Project Title: Land West of Hook Lane, Pagham, near Bognor Regis
Project Reference: JNY8840
Date: 14/05/2019

Application Ref: P/30/19/OUT – WSCC Consultation Response

A	Tactile Paving adjusted & Hook Lane South Access removed	13/03/17	MRA	BRP
Rev	Description	Date	Initial	Checked

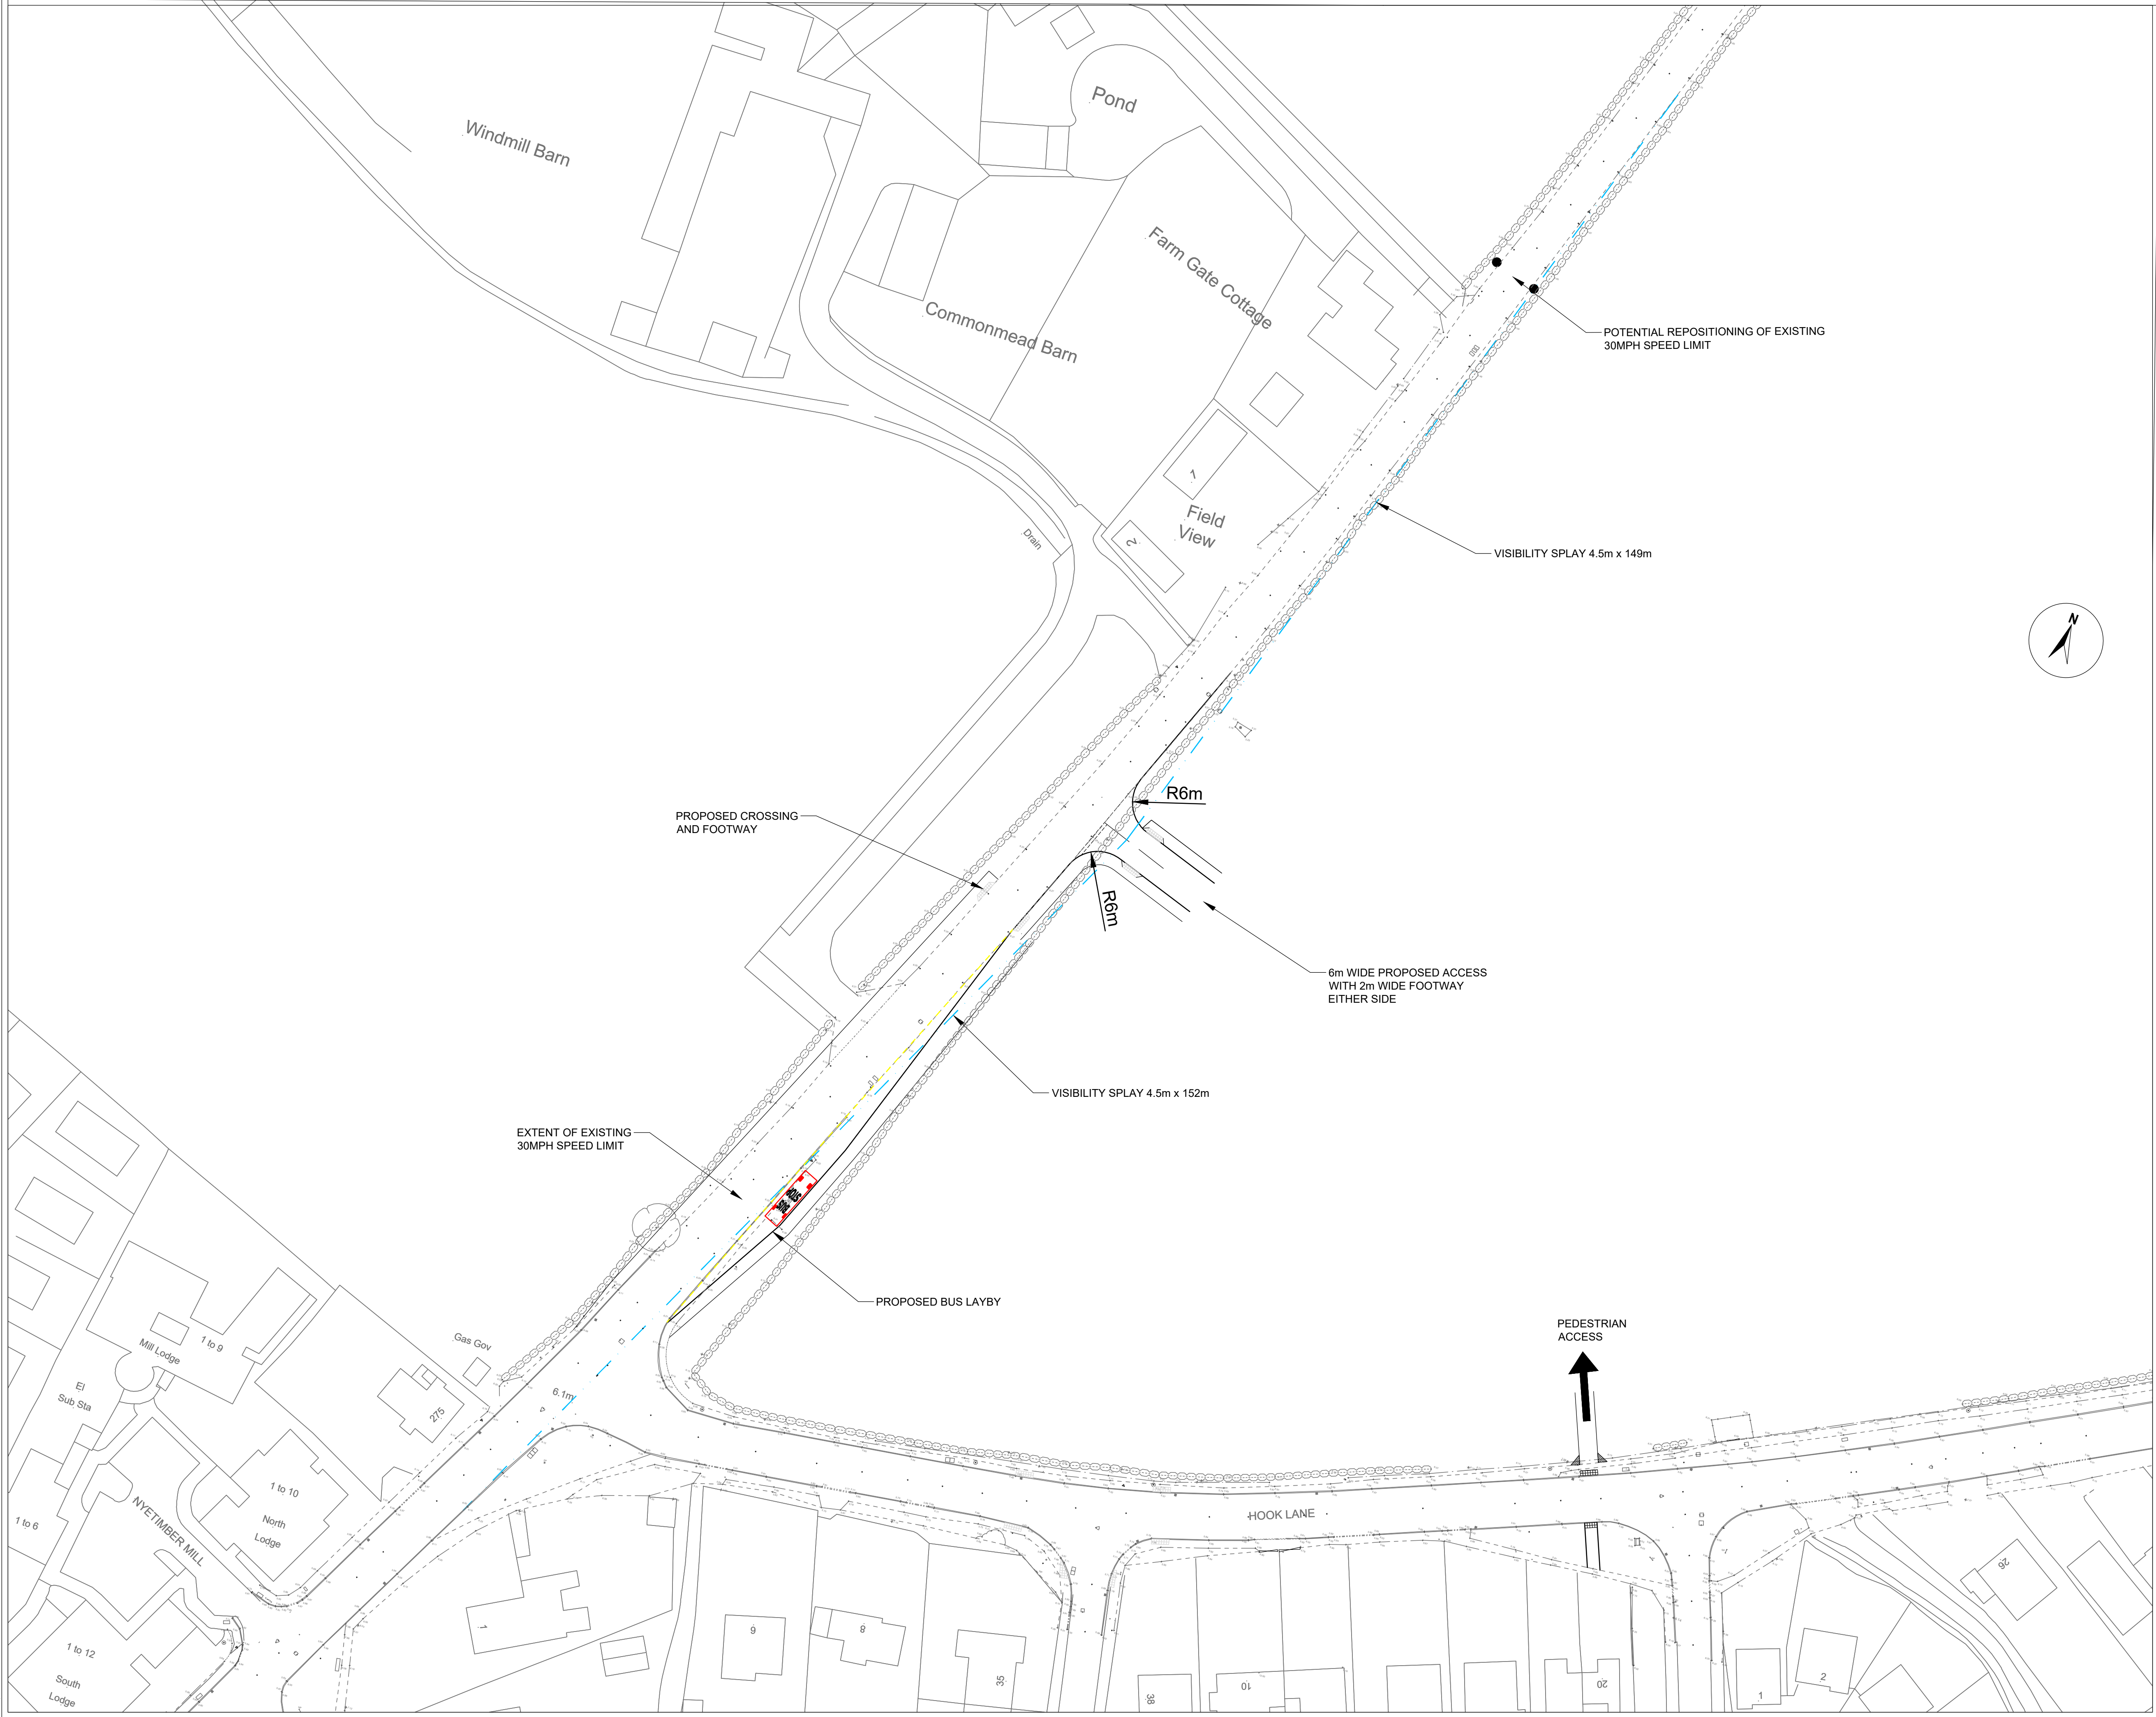
- 1.8 *As noted above, the access onto Pagham Road takes the form of a priority junction. Given the recorded speeds (50.5mph northbound and 50mph southbound (again it's unclear if these are wet weather speeds)) and function of the road, the Design Manual for Roads and Bridges is considered to be the appropriate highway design guidance.*

- 1.9 *Based on the recorded 85th percentile speeds and the DMRB, SSDs of 152 metres to the south and 149 metres to the north are required. These are demonstrated from an X distance of 4.5 metres. The distances are considered acceptable and can be achieved within land forming part of the adopted highway and/or under the control of the applicant.*

- 1.5 The proposal is to provide two points of access, one on Hook Lane, the other on Pagham Road. The reference in the TA for three points of access was an error and should state 2 access which are shown on drawing No.'s JNY8840/09D and JNY8840/12A attached to this Technical Note.

RPS Drawing/Figure Number Rev
JNY8840-09 D

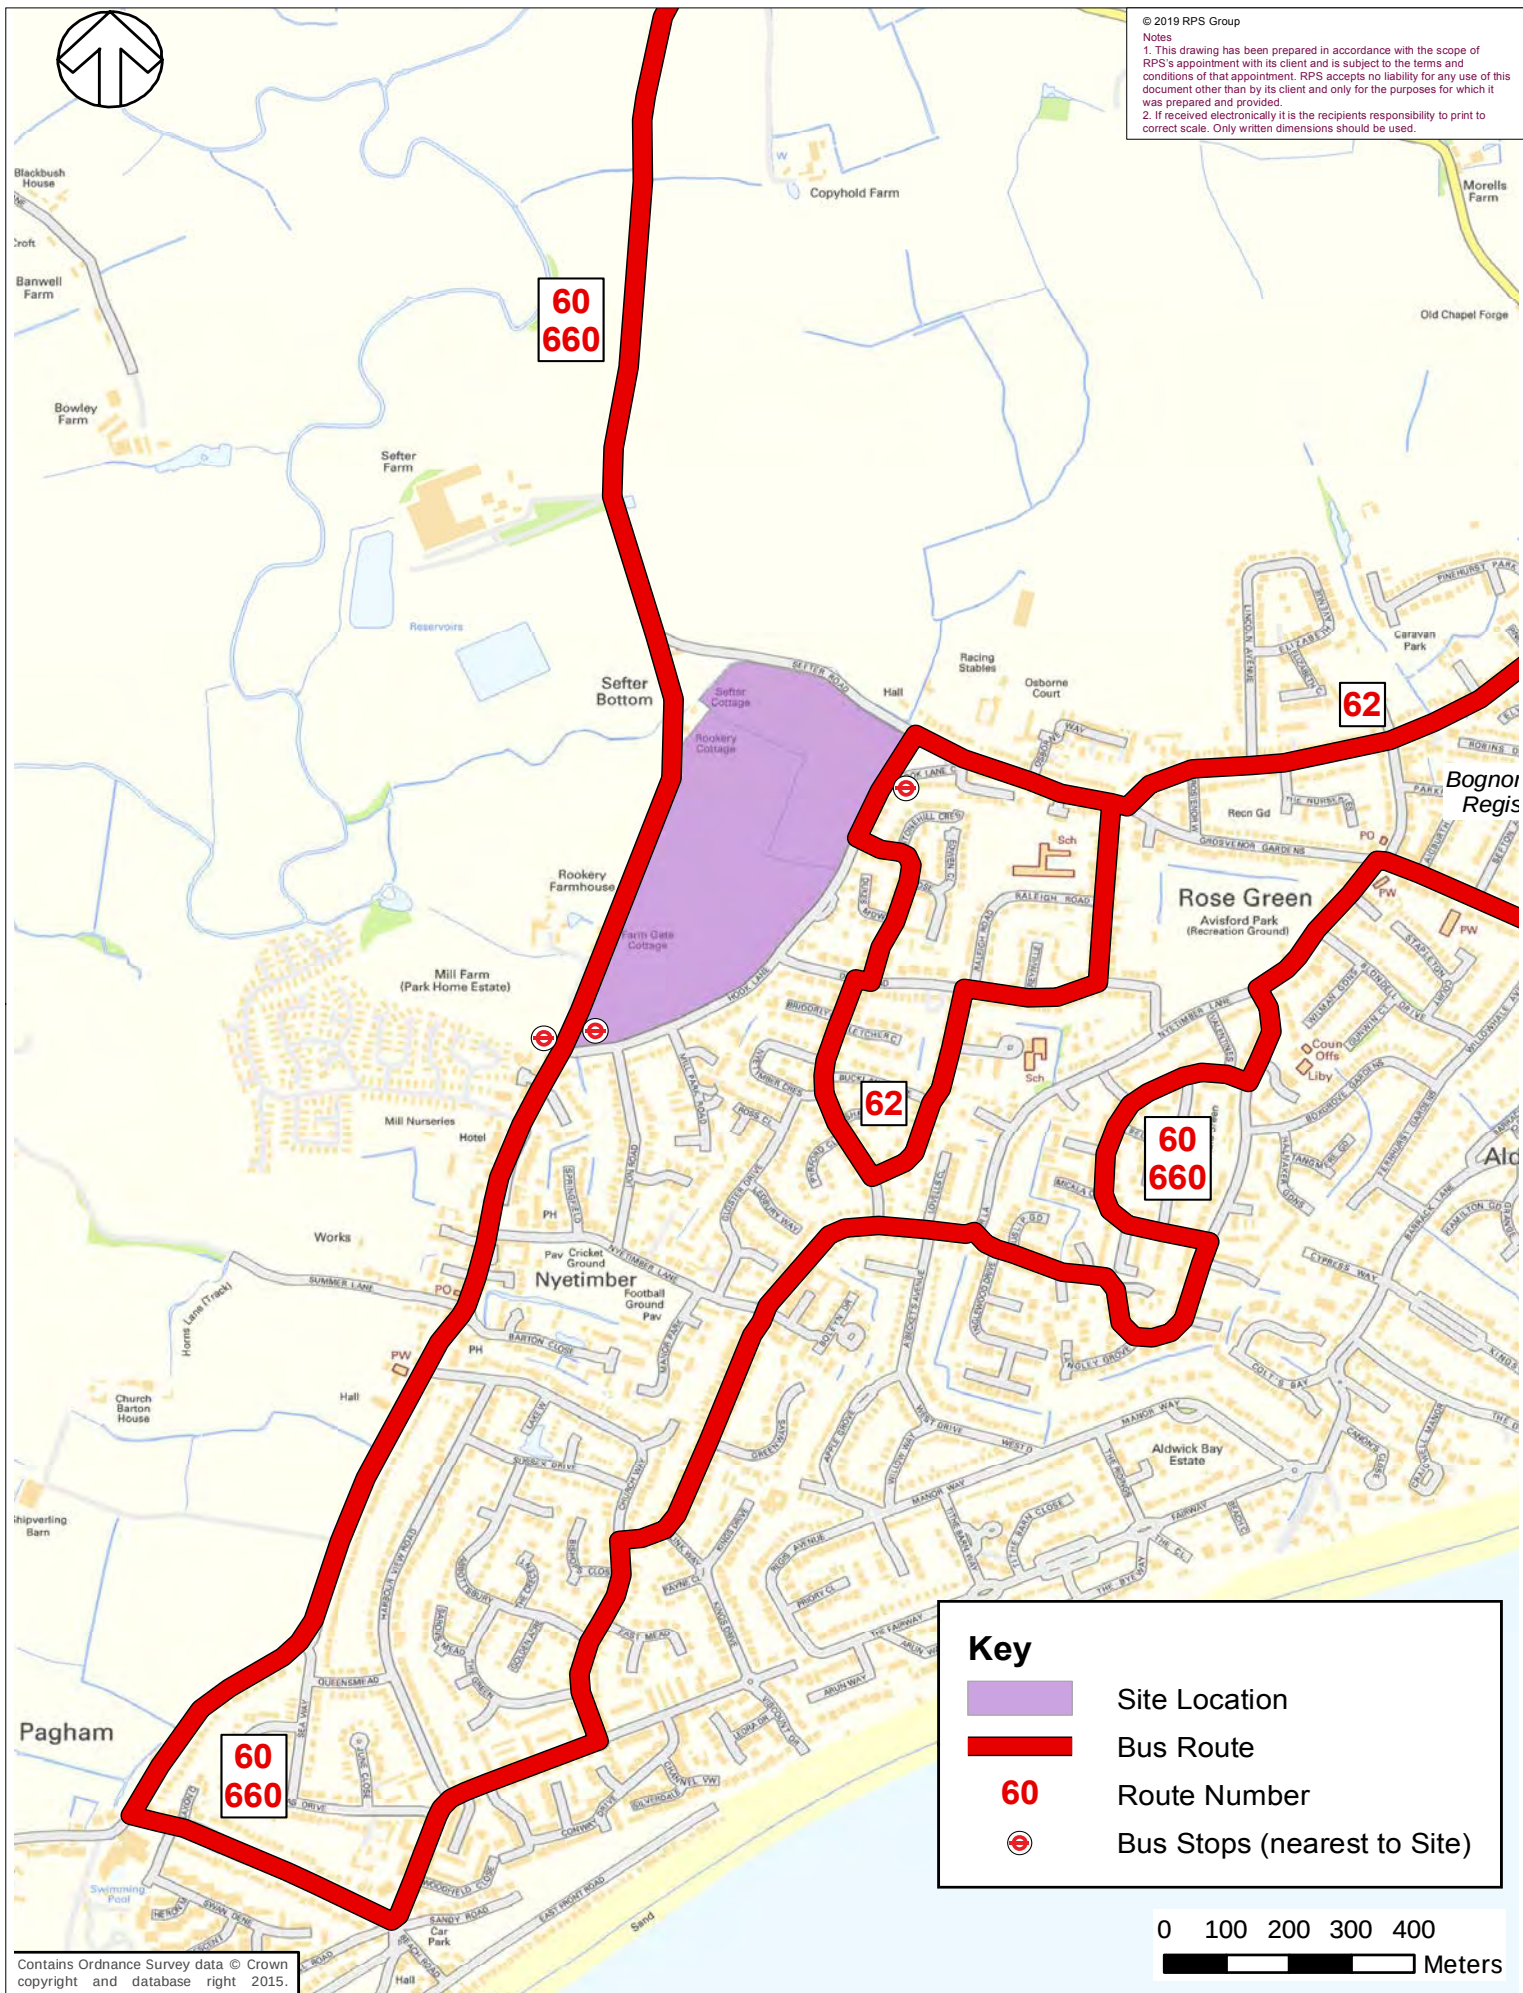
- 1.4 *Whilst there is no objection to the three accesses, there appears scope to rationalise and remove the more southerly Hook Lane access; this access was removed as part of P/6/17. This access is unlikely to be used by any significant volume of traffic in light of the location of the northerly Hook Lane and Pagham Road accesses. It would be requested for consideration to be given to reducing the number of access points onto Hook Lane.*

- 1.7 *In checking the stopping sight distances at the two Hook Lane accesses against the recorded speeds, the sightlines appear to exceed those typically required using MfS Stopping Sight Distances. On this basis, the LHA are satisfied that adequate visibility can be achieved onto Hook Lane within land forming part of the adopted highway and/or land under the control of the applicant. The geometry in all other respects appears acceptable and complies with current guidance.*
